**APPLICATION BY NATIONAL GRID ELECTRICITY TRANSMISSION**  
**FOR AN ORDER GRANTING DEVELOPMENT CONSENT FOR THE SEA LINK PROJECT**  
**(REF: EN0020026)**

**DEADLINE 1A**  
**SUPPLEMENTARY AGENDA ADDITIONAL**  
**QUESTIONS**  
**PORT OF LONDON AUTHORITY**

## Shipping and Navigation

Document 9.104: Areas of Safeguarded Water Depth Plan

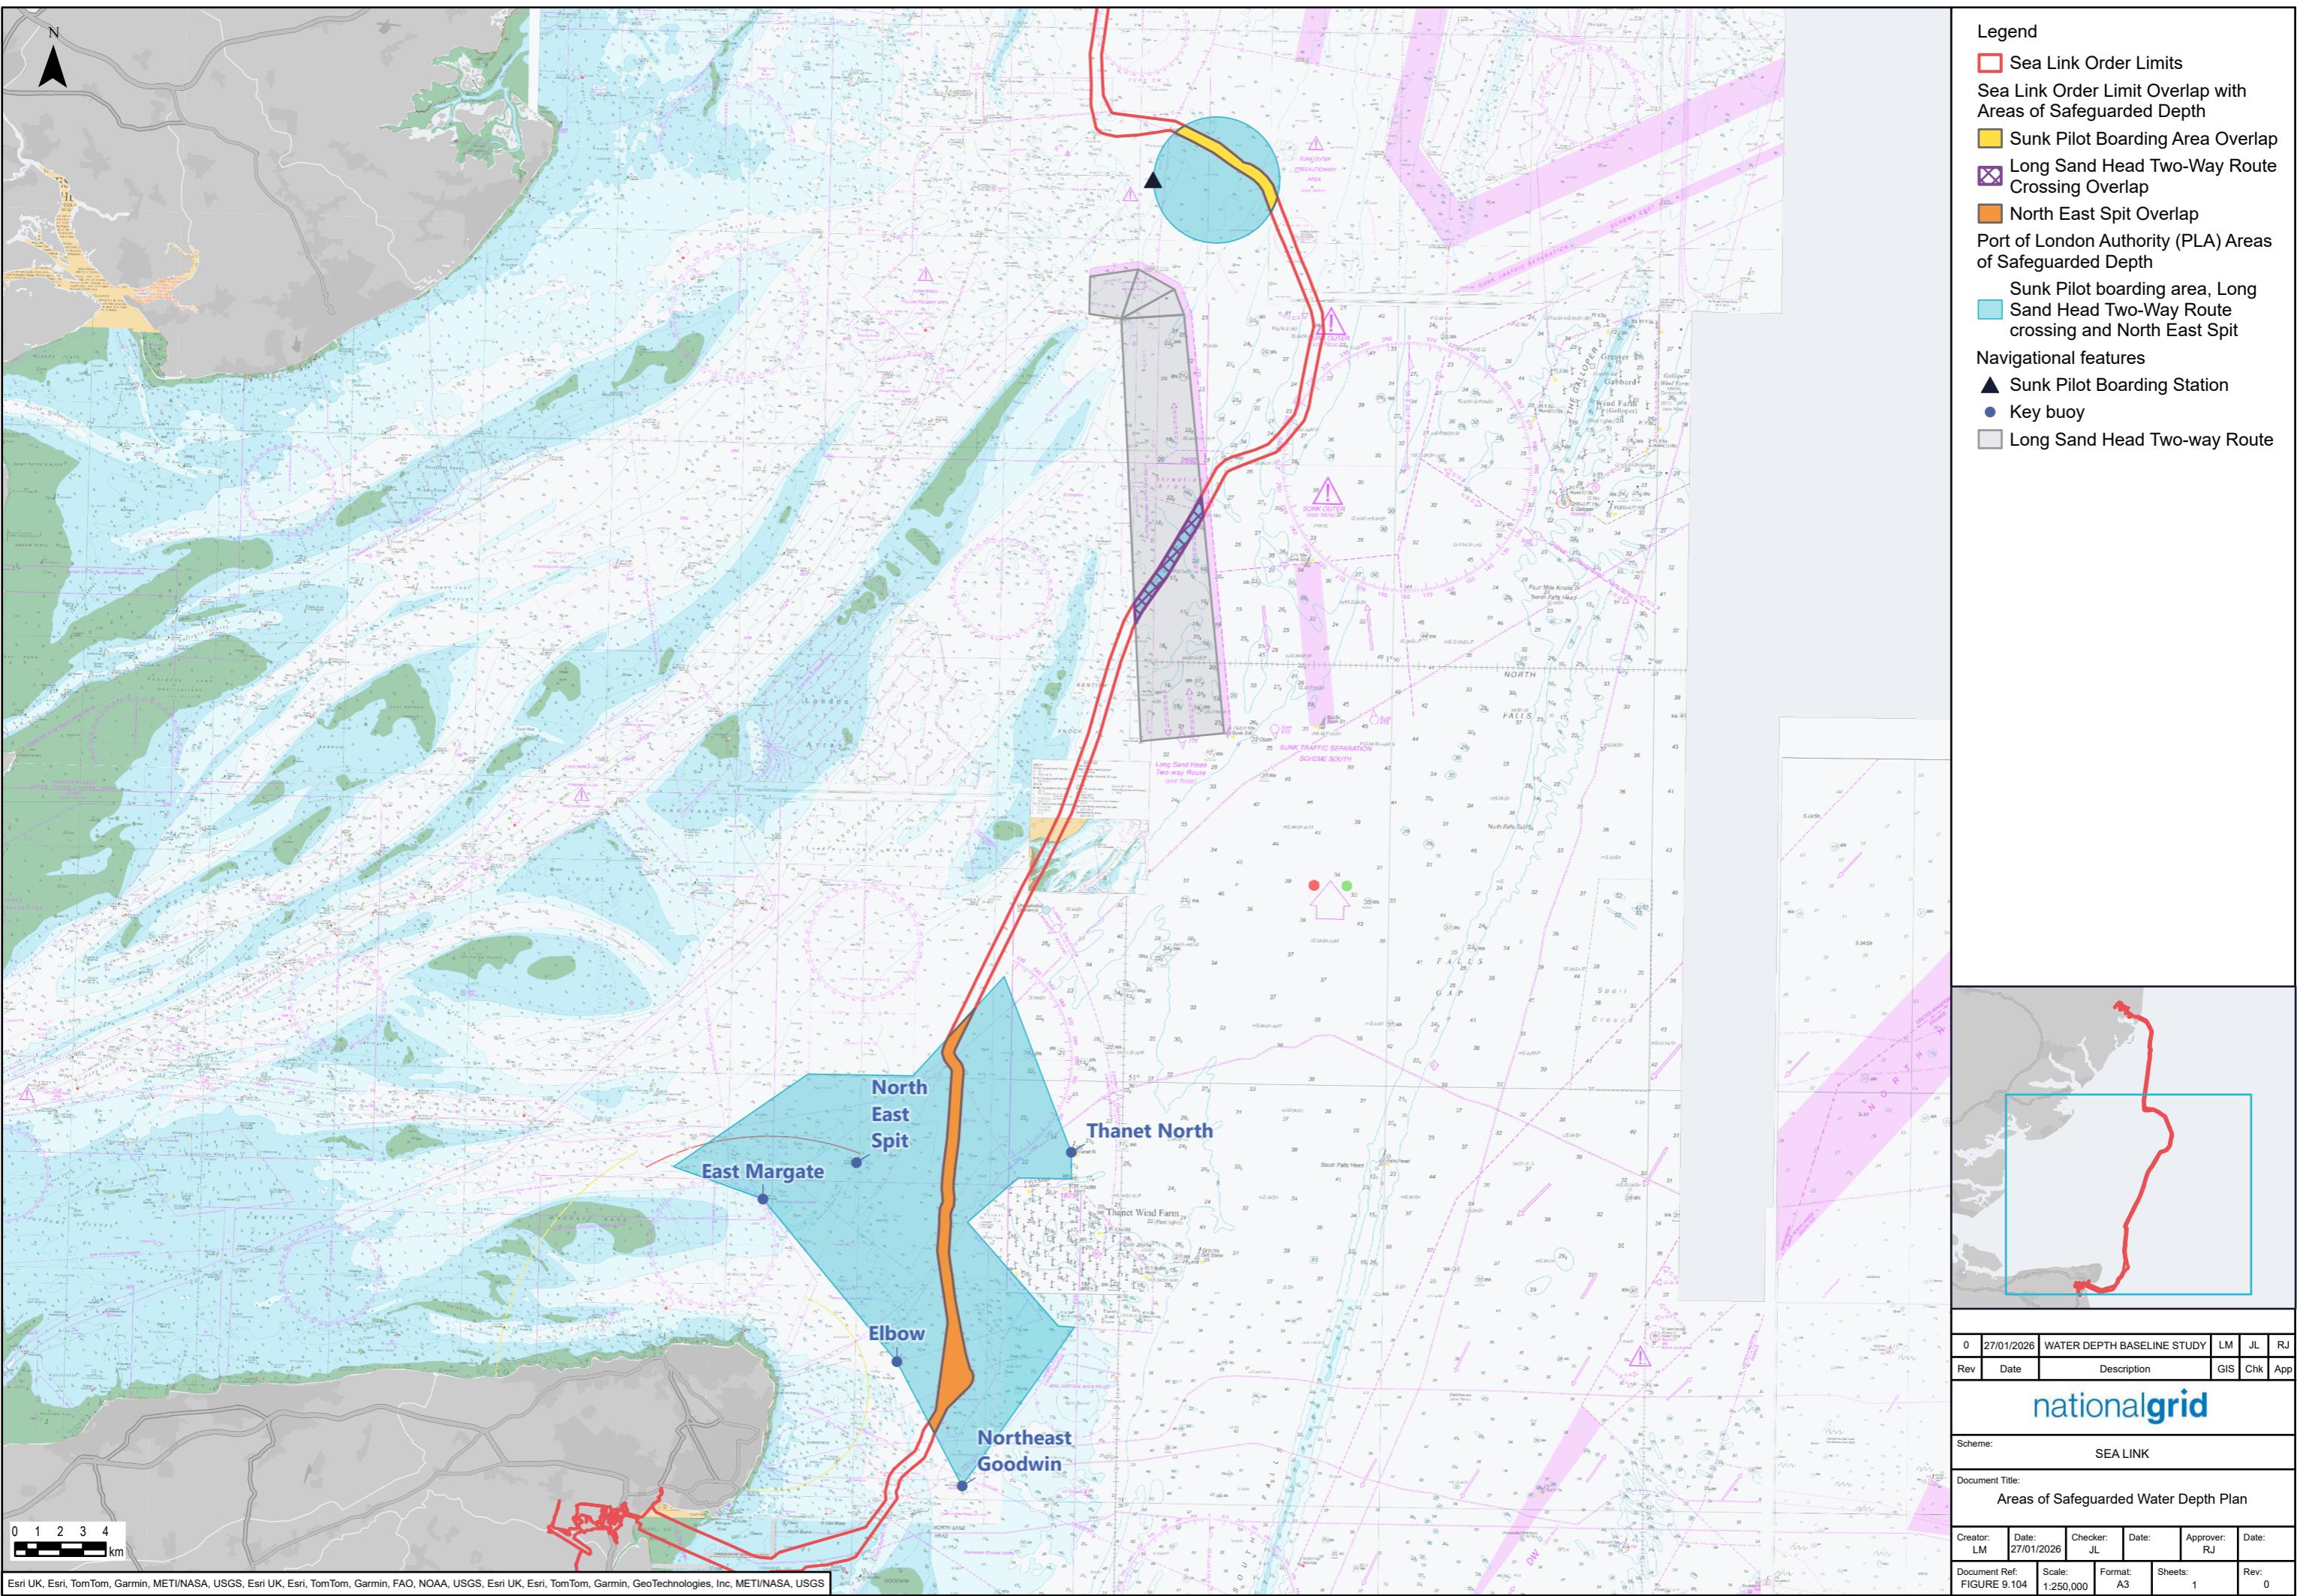
Number	Response by	Question / Clarification	PLA Response
ISH1.06	MCA Port of London Authority Harwich Haven Authority London Gateway Port Ltd	Do you have baseline information for the depth below chart datum across the Sunk and other important shipping routes on the proposed cable route? If so, please provide a summary of the information to the ExA.	<p>The Port of London Authority (“PLA”) has included within its Written Representation three areas where charted depth is critical to shipping (see paras 3.5-5.6 and figures 3-5). These are the Sunk, the Long Sand Head two way route, and the North East Spit.</p> <p>Rather than relative reductions in existing depths, the PLA is of the view that absolute depths need to be safeguarded for the protection of future navigation.</p>
ISH1.07	MCA Port of London Authority Harwich Haven Authority London Gateway Port Ltd	What would be the effects of a reduction in under keel clearance below 22 metres in the Sunk or other key areas for large vessel traffic to ports?	<p>The PLA has addressed this point in its Written Representation see paragraphs 5.3 - 5.5.</p> <p>In summary:</p> <ul style="list-style-type: none"> <li>- If water depths of -22m CD are not safeguarded at the Sunk this will significantly reduce the area within which the boarding and landing of future deeper draughted vessels can take place and may severely restrict their access in and out of the port. There would be an increased risk of collision for very large vessels if they are required to manoeuvre for boarding and landing within a more restricted area.</li> </ul>

<ul style="list-style-type: none"> <li>- The Long Sand Head two way route feeds into the Trinity Deep Water Route and allows less deep draughted vessels that are entering or exiting the Port of London to take a pilot at the North East Spit and avoid travelling up to the Sunk pilot station via the Sunk roundabout. This flexibility is particularly important during periods of disruption to the Sunk routes, either due to adverse weather closing the Sunk pilot station or due to construction and maintenance activities of various planned cables. If water depths of -12.5m CD are not safeguarded then additional constraints will be placed on vessels that use this route.</li> <li>- If water depths of -12.5m CD are not safeguarded at the North East Spit this will significantly reduce the area within which the boarding and landing of future deeper draughted vessels can take place and may ultimately prohibit some vessels from using the North East Spit for boarding and landing.</li> </ul>
